ARCHITECTURAL INNOVATIONS, P.S.
Forward Thinking Design Solutions For Your Environment

RE: AI Job #20012

Project Address: 7621 SE 22nd ST

Subject: Permit No. SUB21-006

**PRELIMINARY SHORT PLAT MAP**

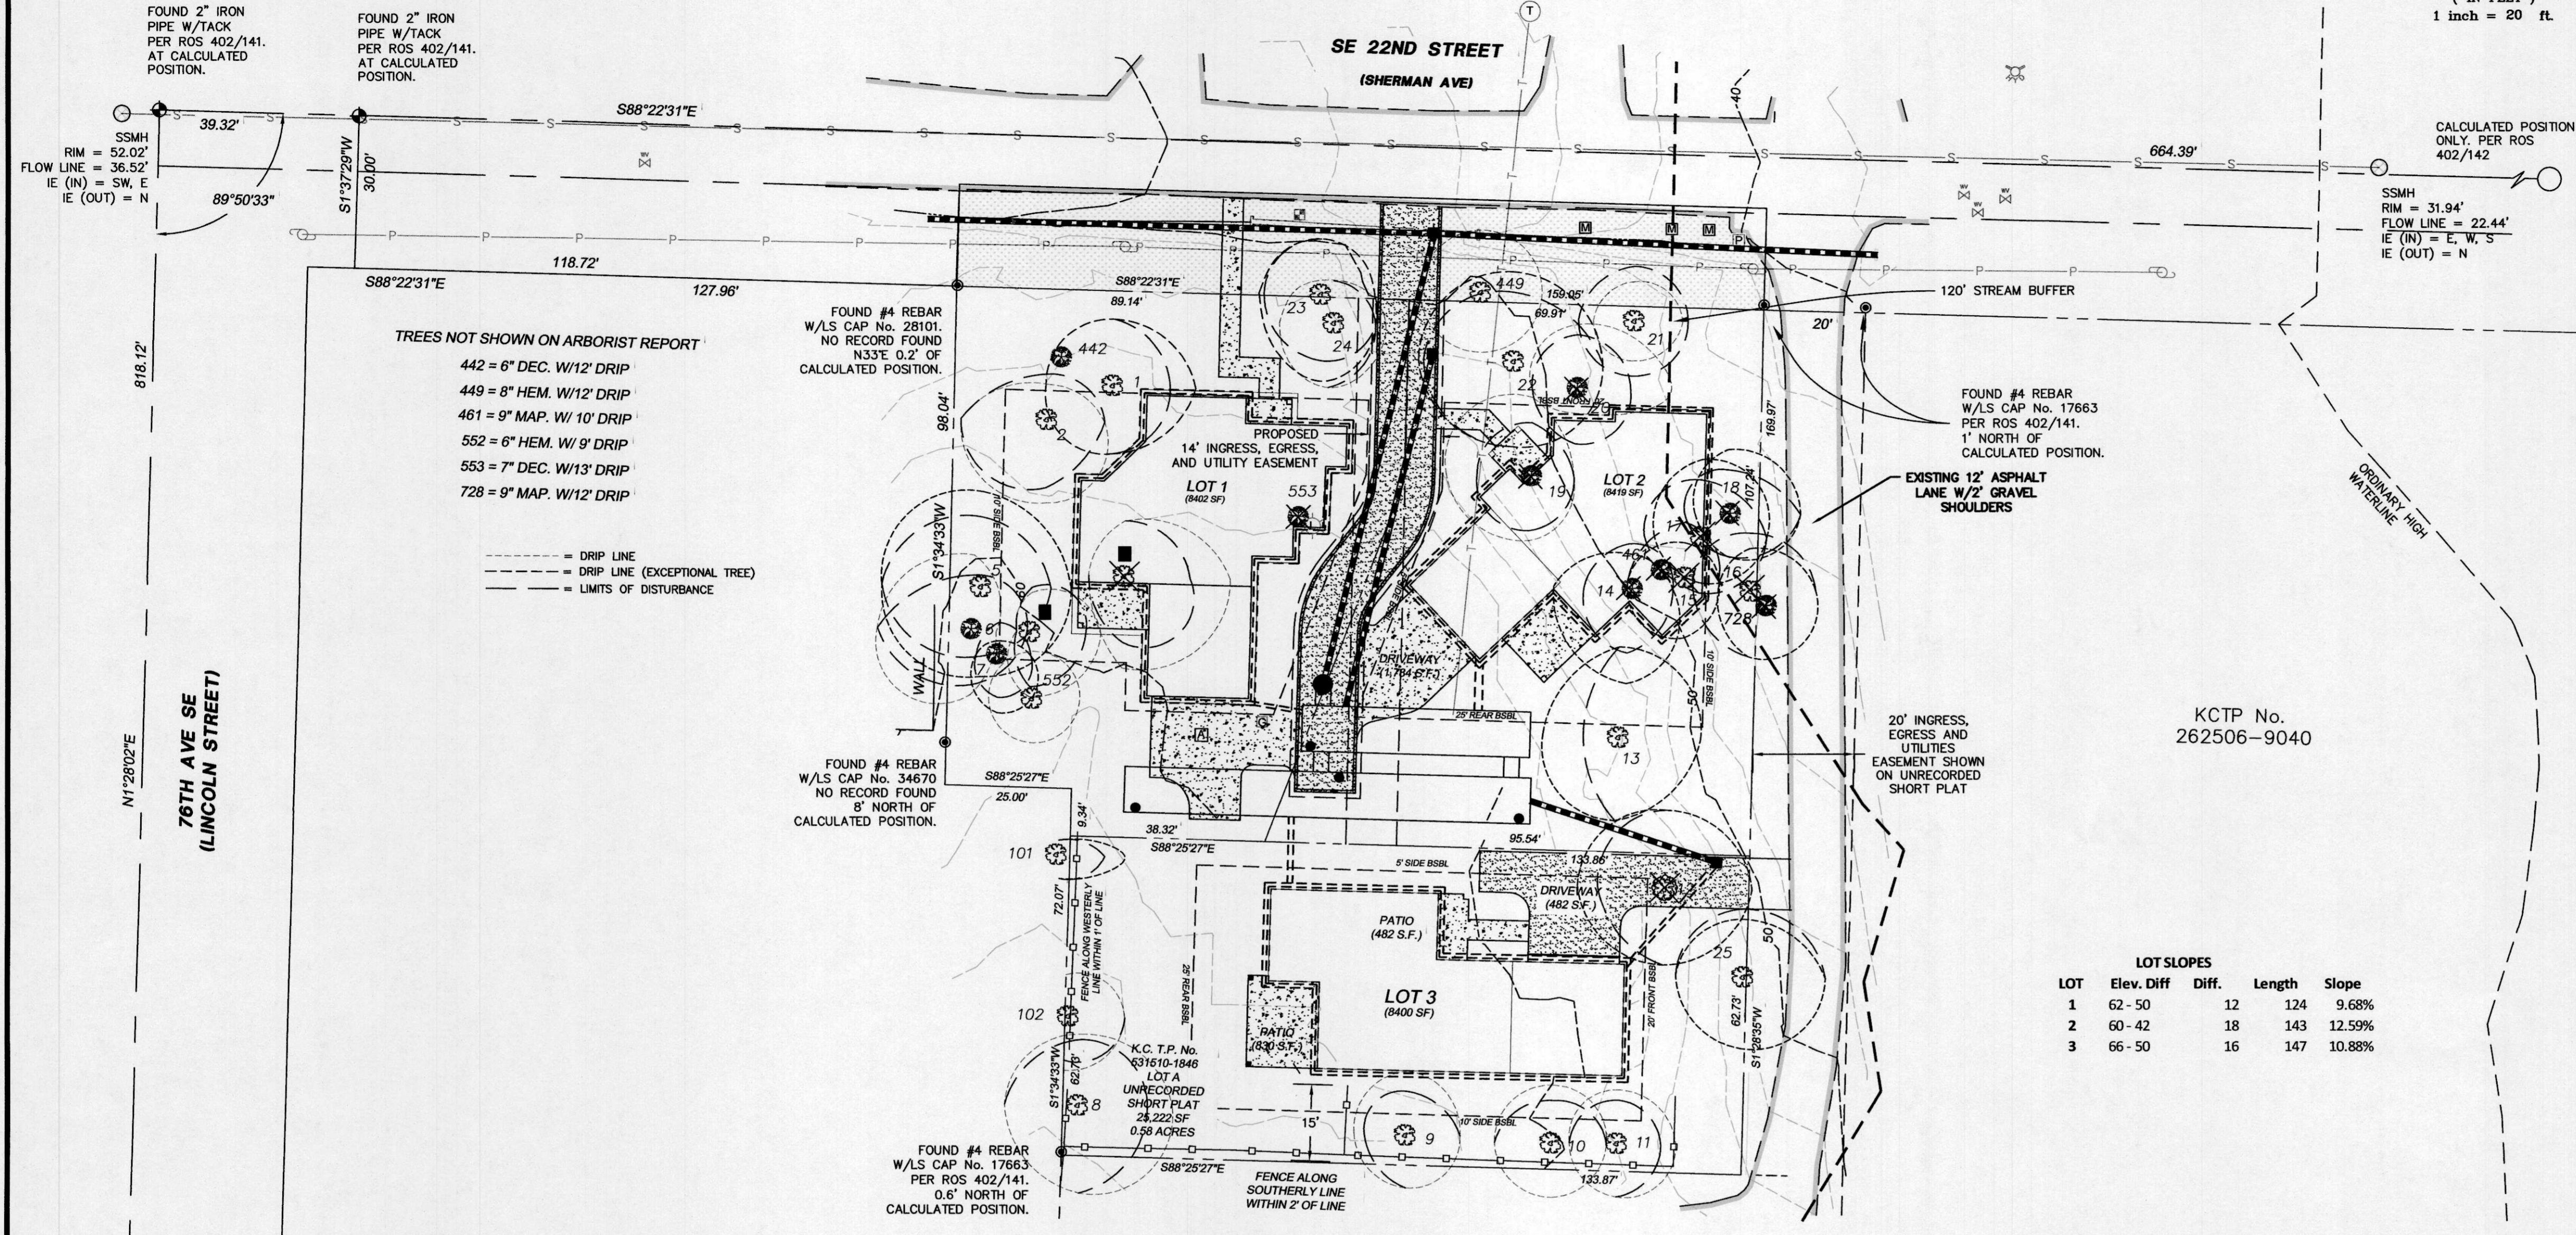
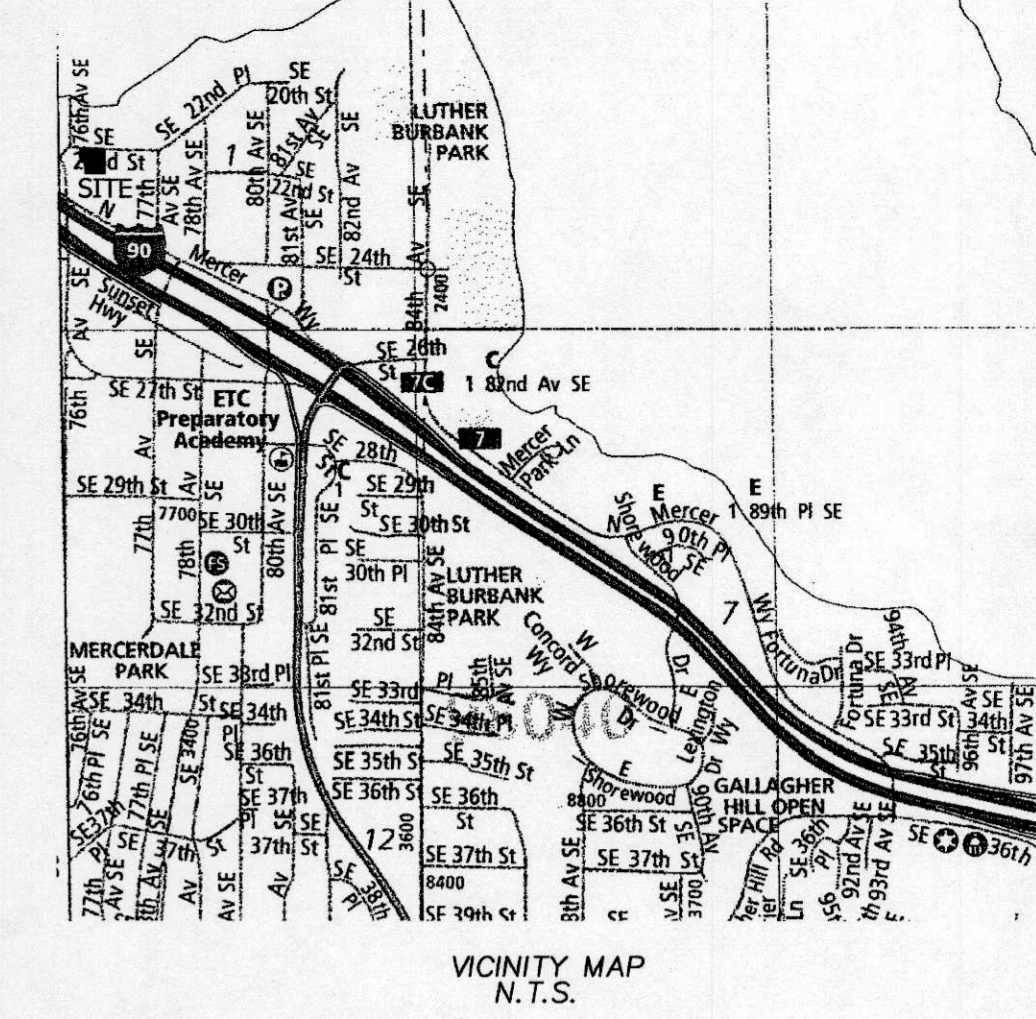
3. See item 2 above.
4. Existing lot dimensions, size, and coverage are noted on the survey. The preliminary site plan notes all proposed lot dimensions, lot size, and lot slope. As for coverage the footprints and hardscape areas are preliminary at this point. What is shown on the preliminary site plan represents the approximately the maximum allowable coverage.

5. All existing structures and hardscape are proposed to be removed. A note has been added to the preliminary site plan.
6. The note has been added to the preliminary site plan.

PRELIMINARY TREE PROTECTION PLAN

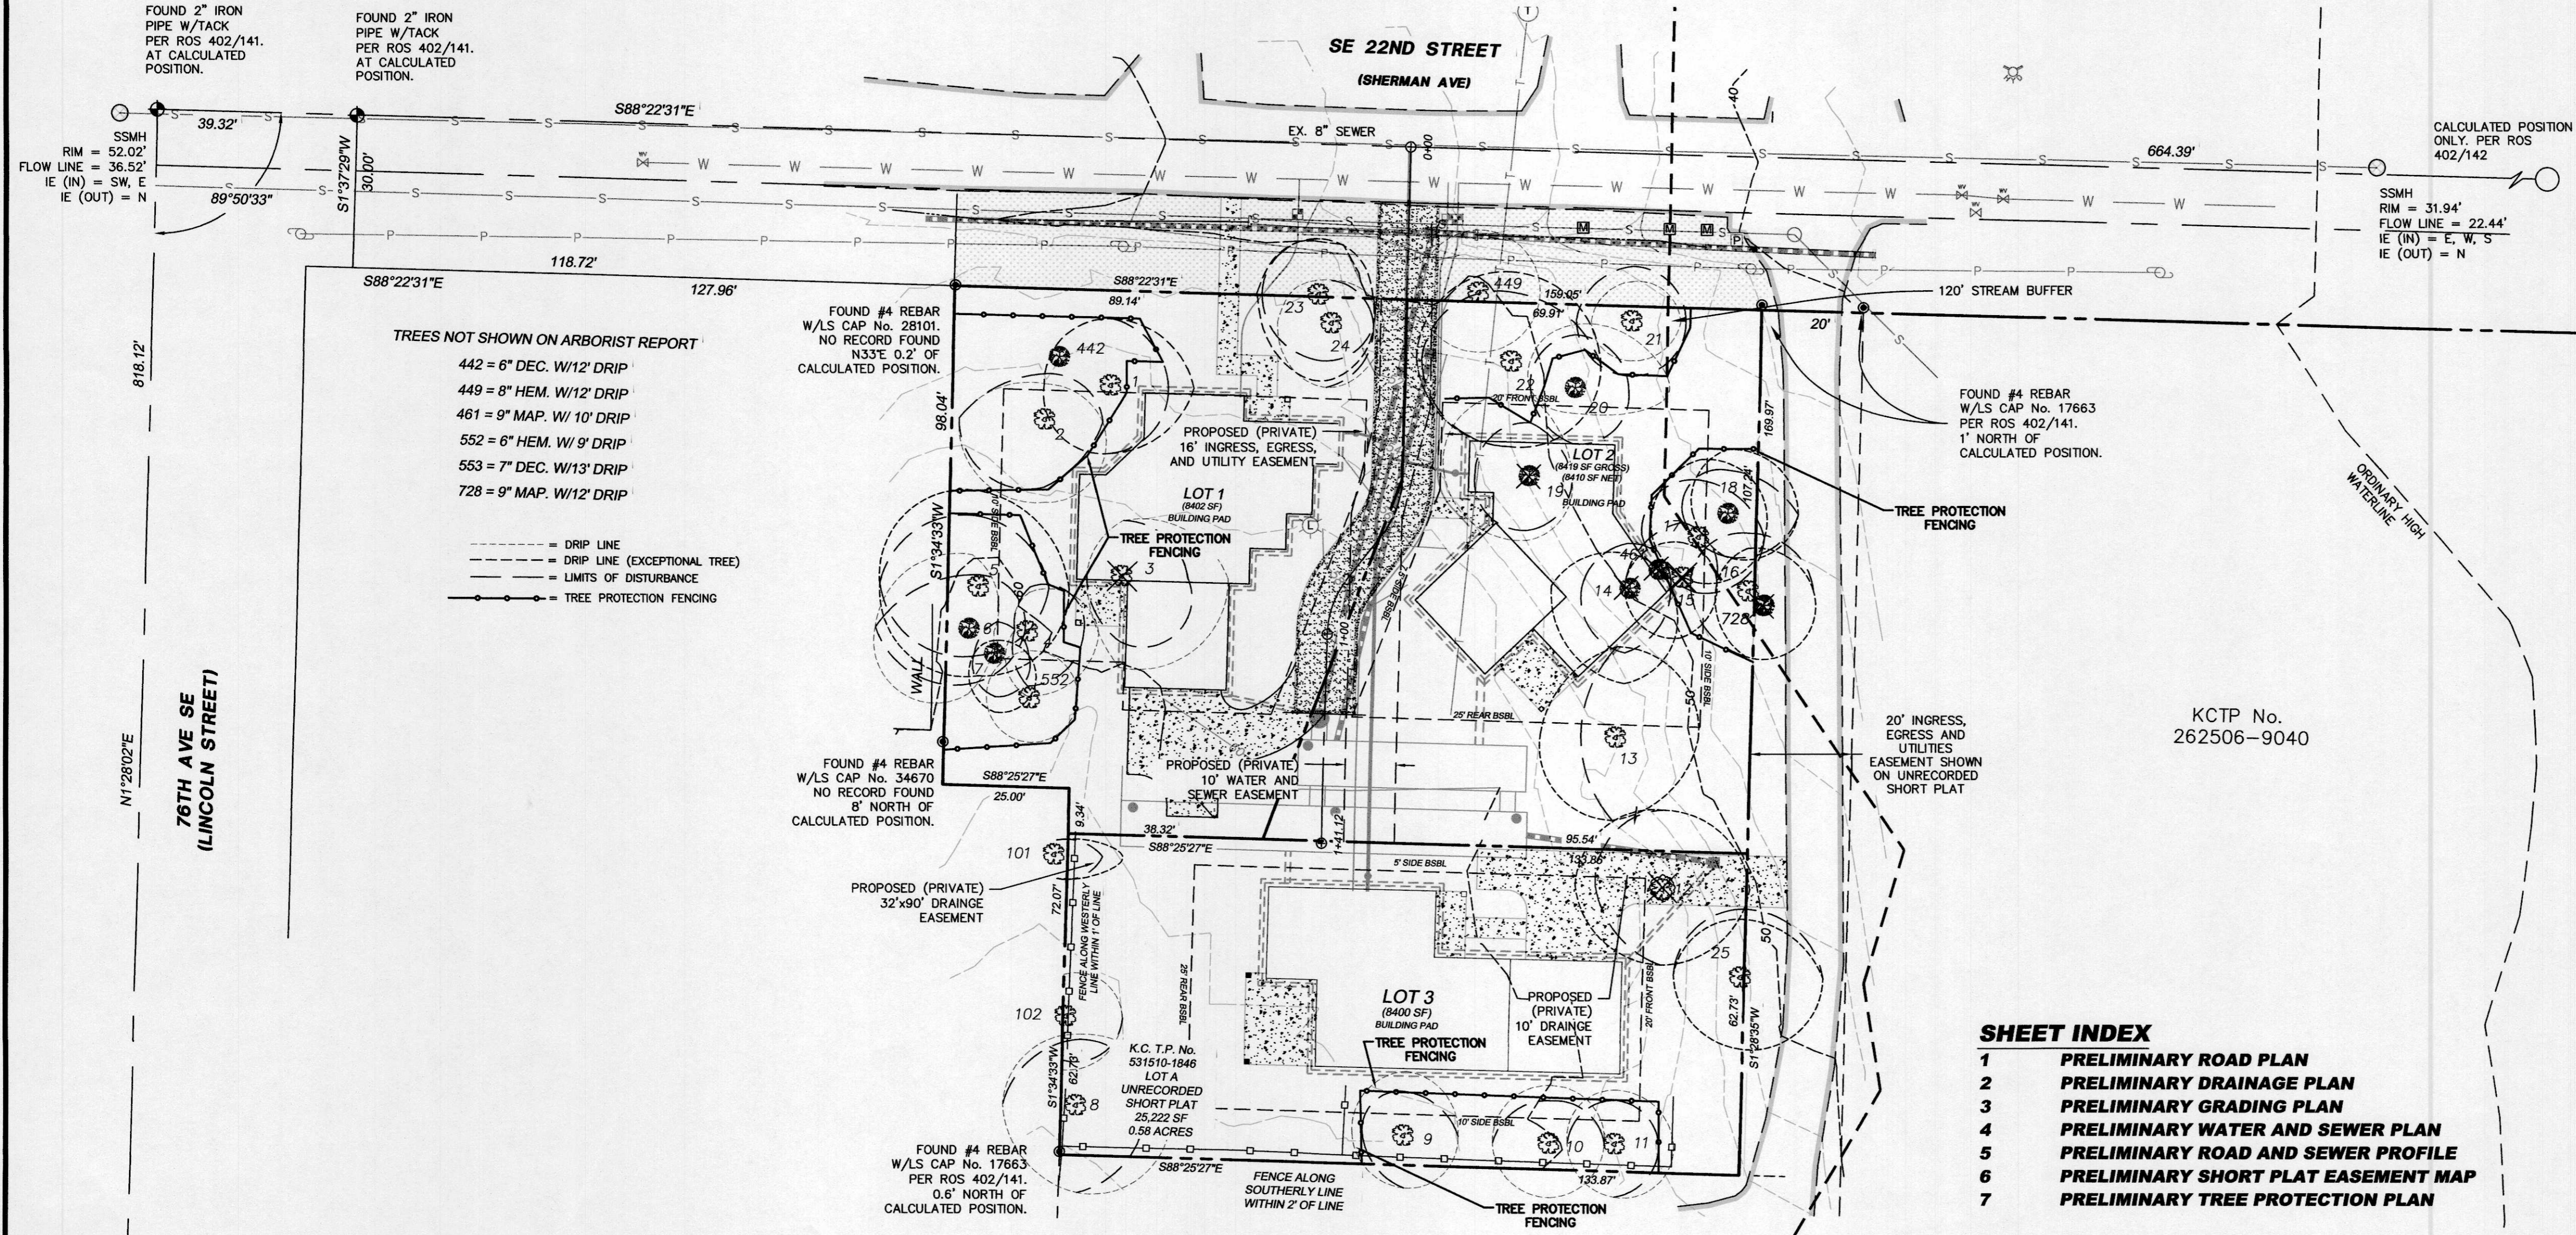
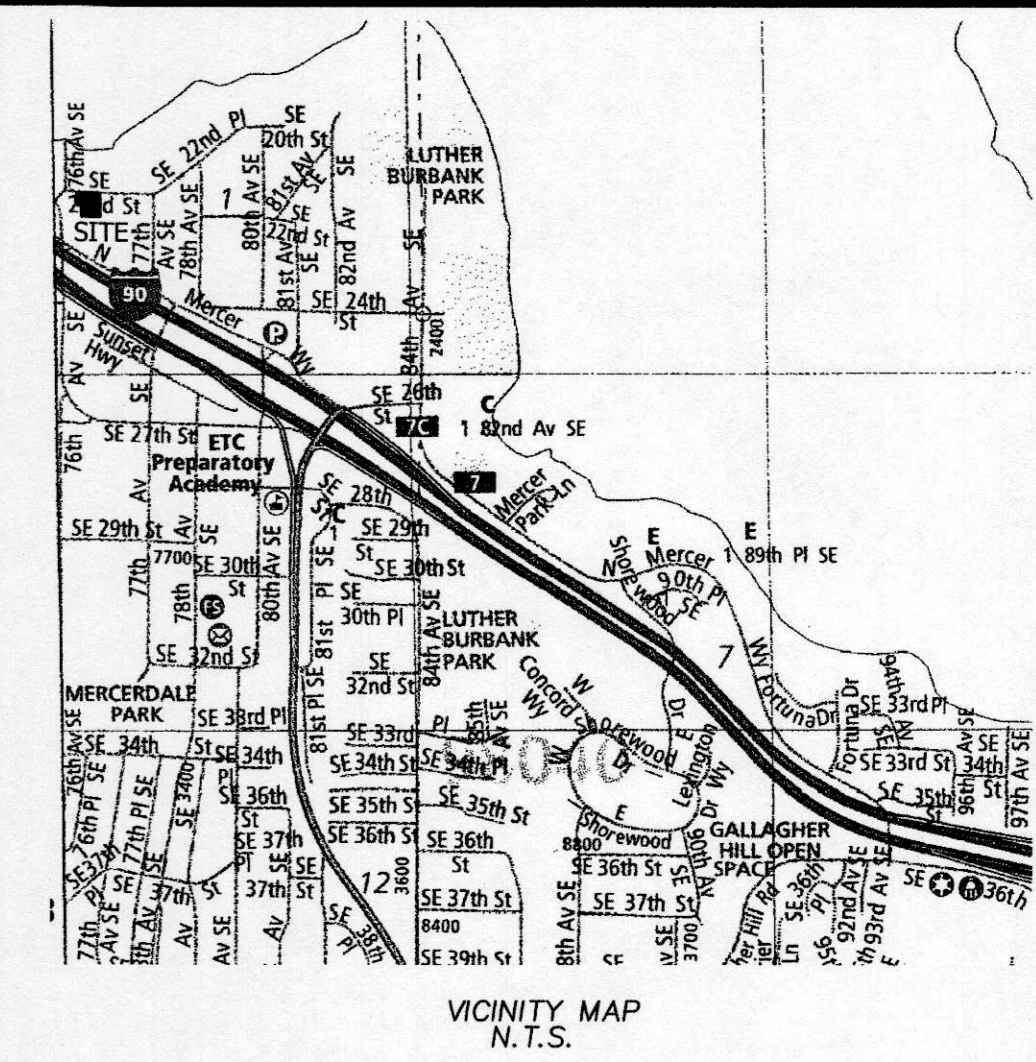
1. All of the driplines have been updated/added as well as the limits of disturbance.
2. We are requesting the removal of the exceptional grove trees, numbers 12, 14, 15,16,17 and 18. We believe we have met the requirements for the removal under MICC19.10.060.3 as the retainage of these trees effectively renders the lot unbuildable and we would see a reduction in the gross square footage allowed of approximately 1120 sf or about a 33% reduction in the from the allowed gross square footage. Further, the retainage of tree #12 eliminates any viable access for lot 3. The site was carefully laid out to preserve the maximum amount of trees to be retained. We are proposing to keep 62% of the existing trees and except for the aforementioned grove, we are keeping all of the exceptional trees.

3. All driplines and area of disturbance have been added/corrected. At this time, we would elect address the tree protection plan later as the building footprints are still a preliminary design.
4. The tree summary table and tree inventory & replacement form have been revised to reflect the exceptional status of the grove trees. With that said as proposed the current tree replacement quantity is 42 trees. With the amount of trees remaining on the lot and the room left we would like to request to do a Fee-in-Lieu of per 19.10.010.C.1 for a portion of the replacement trees.
